Planning Services  
Department of Planning and Environment  
GPO Box 39  
Sydney NSW 2001

**Re: Re: Objection Submission –State Significant Development Application SSD 9741 Lane Cove West Data Centre**

13 May 2019

Drawing Title
18 HEIGHT DIAGRAM

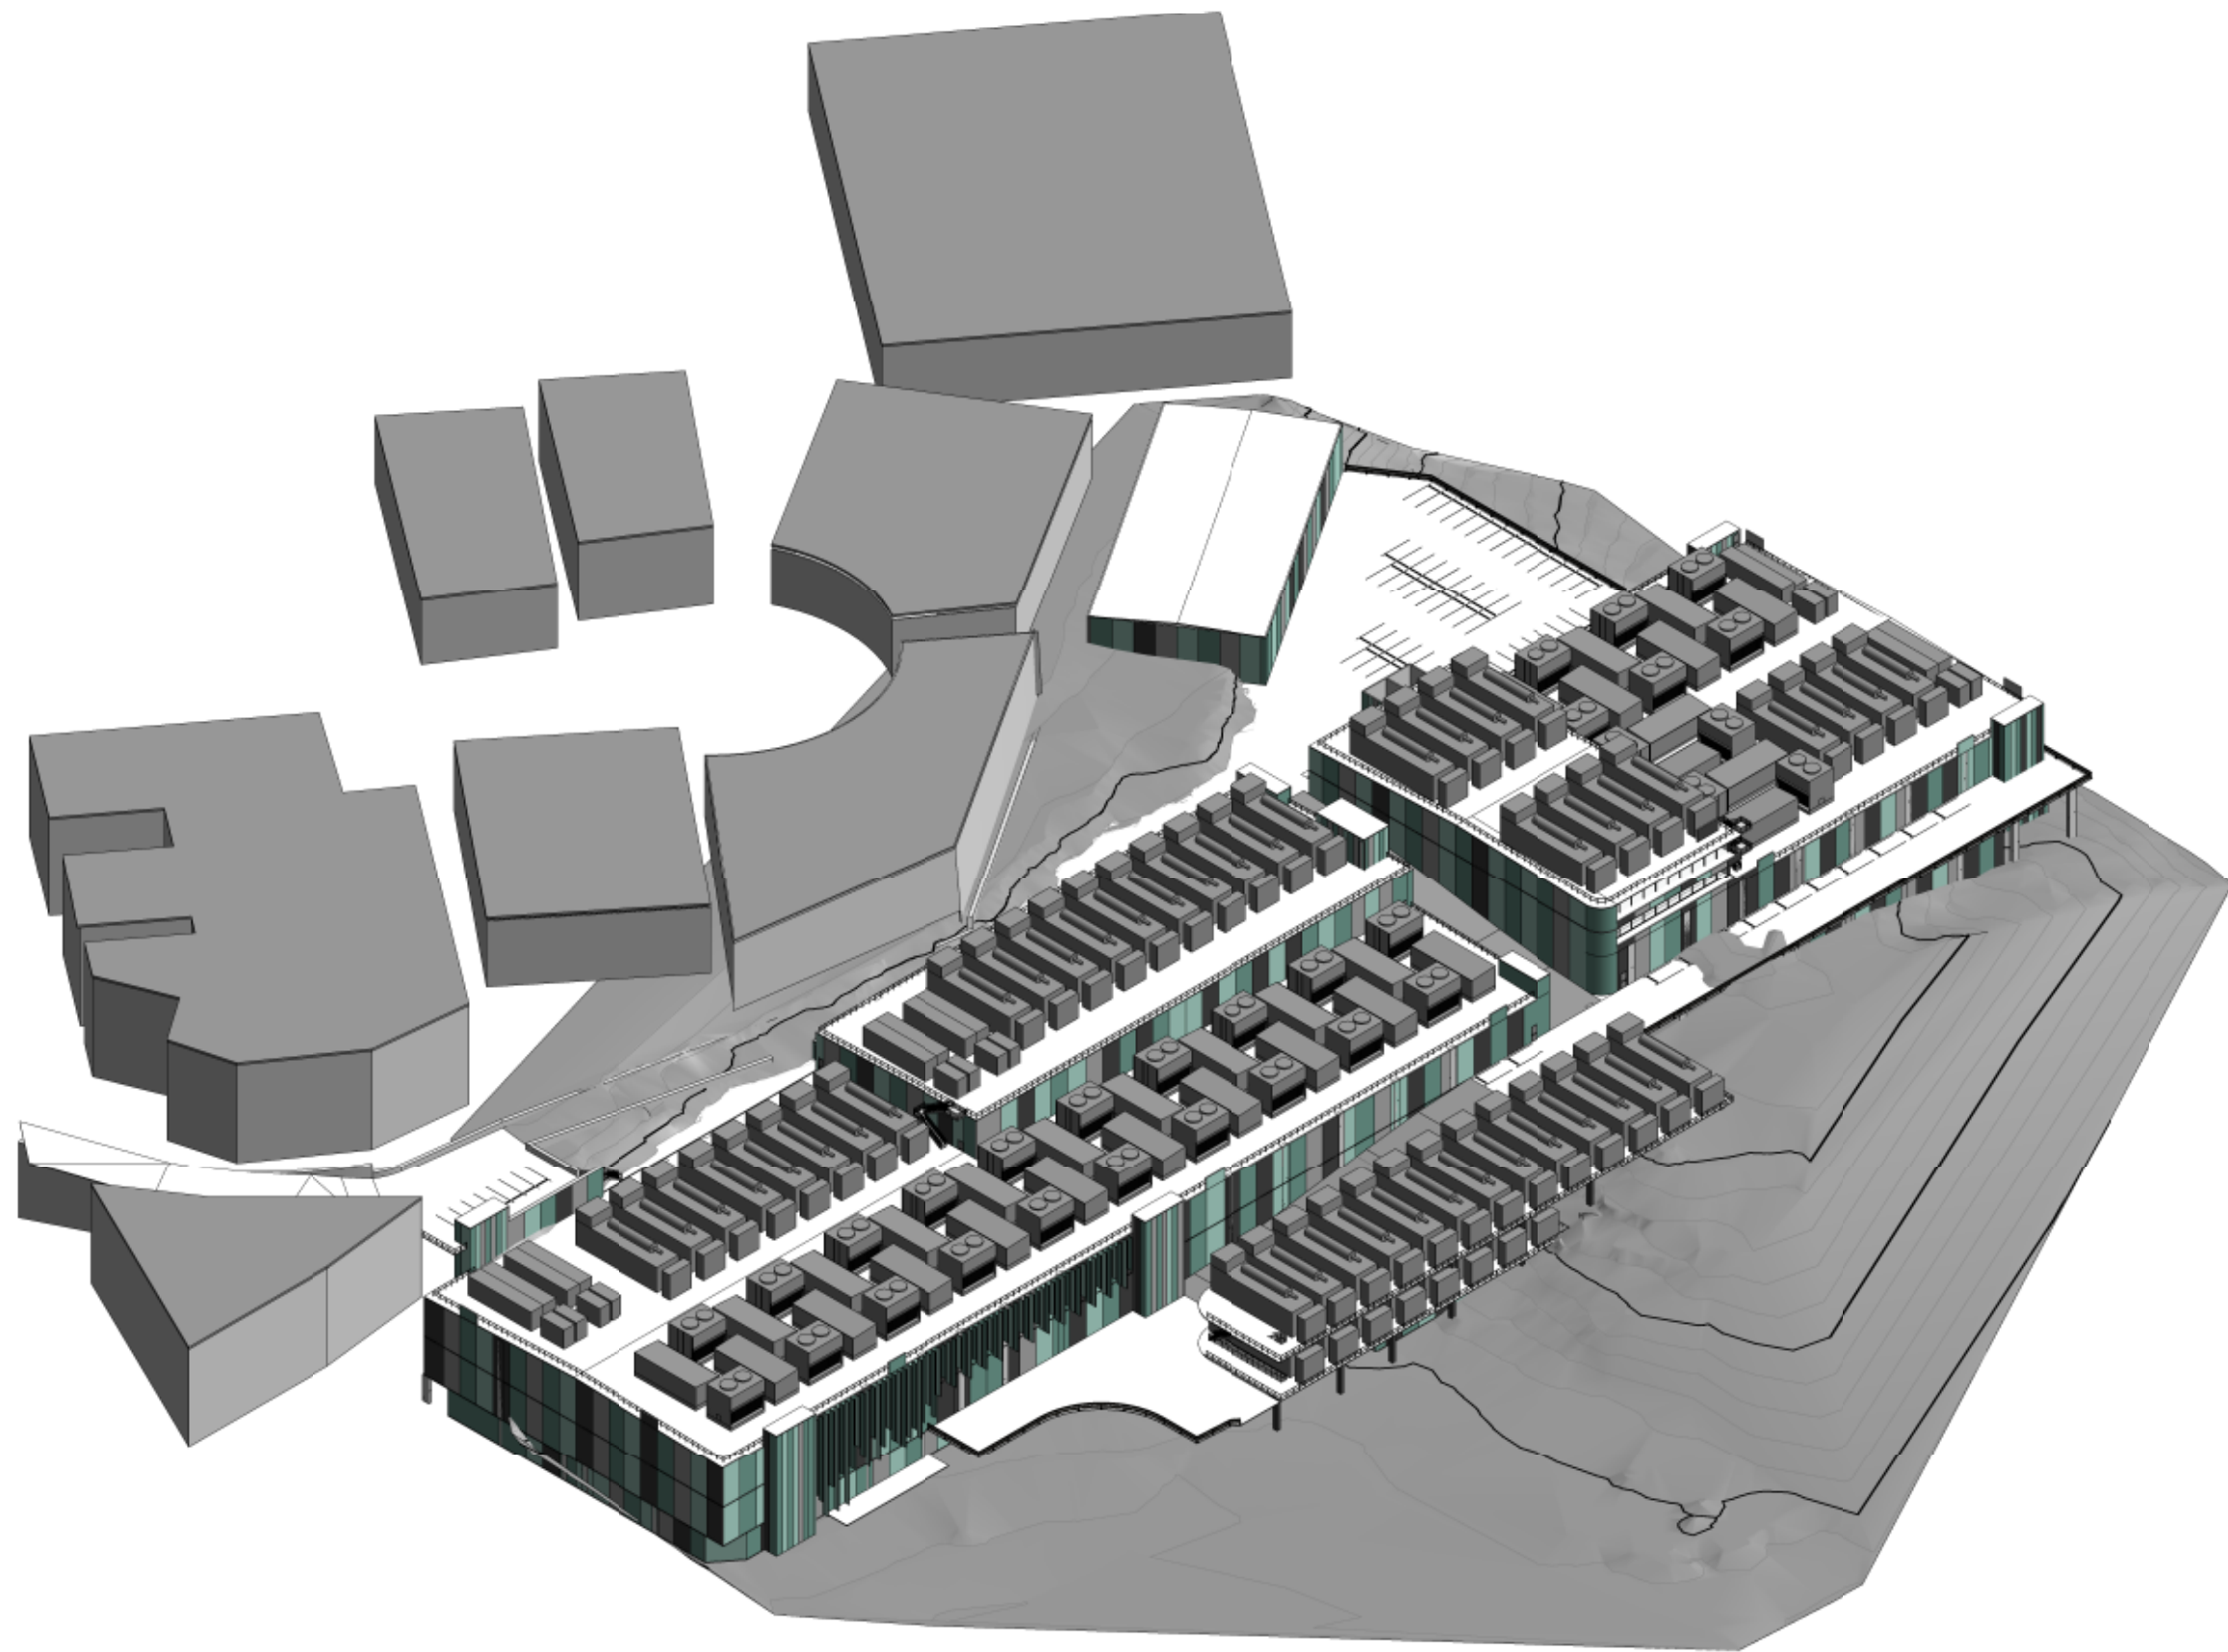
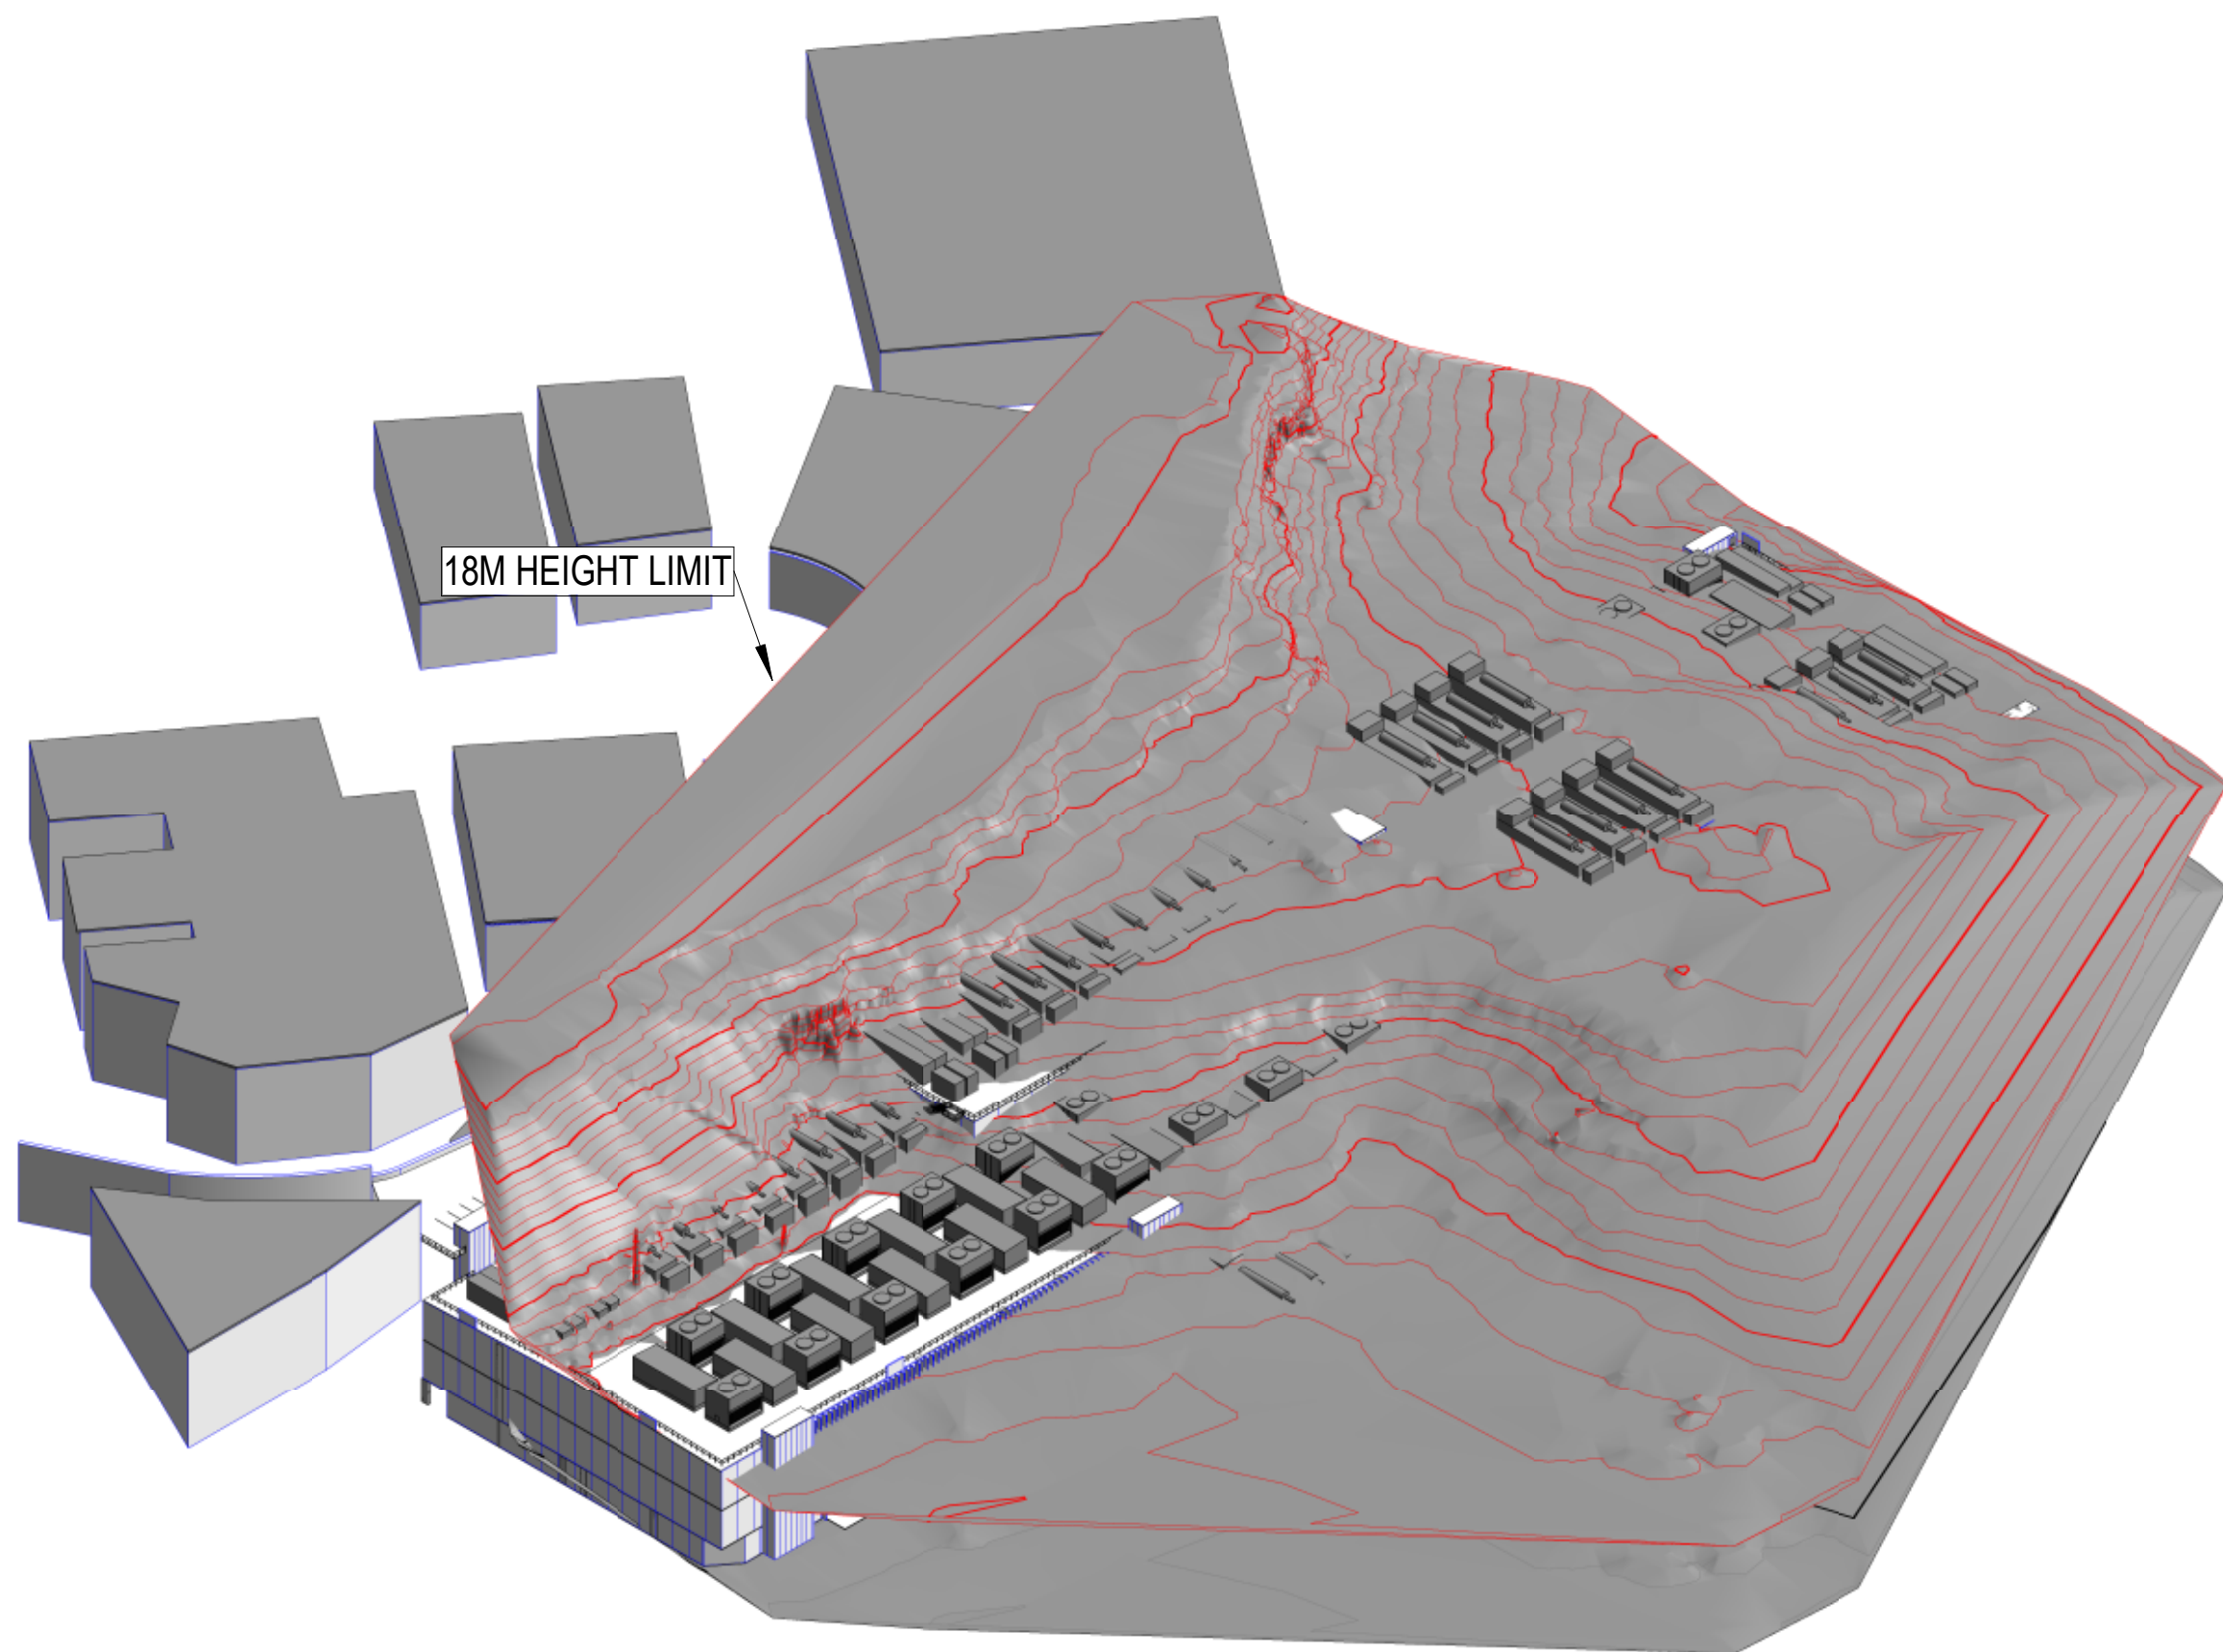
5. **Objection:- Bulk and Scale of the Development, and exceeds LEP height.** The clause 4.6 Variation - Height of Buildings - is not considered to provide sufficient justification. Much of the justification for exceeding the height is claimed to be forced upon the proponent by its need for consistency with the surrounding industrial character - but the visual impacts of development on neighbouring property of public reserve land, which is where zones meet, is completely ignored in the analysis. Of the Objectives, it is contrary to *“(b) to ensure that privacy and visual impacts of development on neighbouring properties, particularly where zones meet, are reasonable.”* The proposal exceeds height considerably, and in doing so, it does not meet Objective *“(d) to relate development to topography “*. The same problem applies to the argument about whether meeting the standard is unreasonable or unnecessary - it fails to even consider the public domain of the bushland reserve, the walking tracks, the river, and the surrounding urban areas of Lane Cove and Ryde, which will see the intrusive development in the riverland context. In this case, the test of Clause 4.6 is failed because the flexibility for height sought in the proposal does not achieve *“better outcomes from development “* but produces worse outcomes from the development for all but itself. It is only the proponent, and their tenant, who benefits from the flexibility. Others suffer.
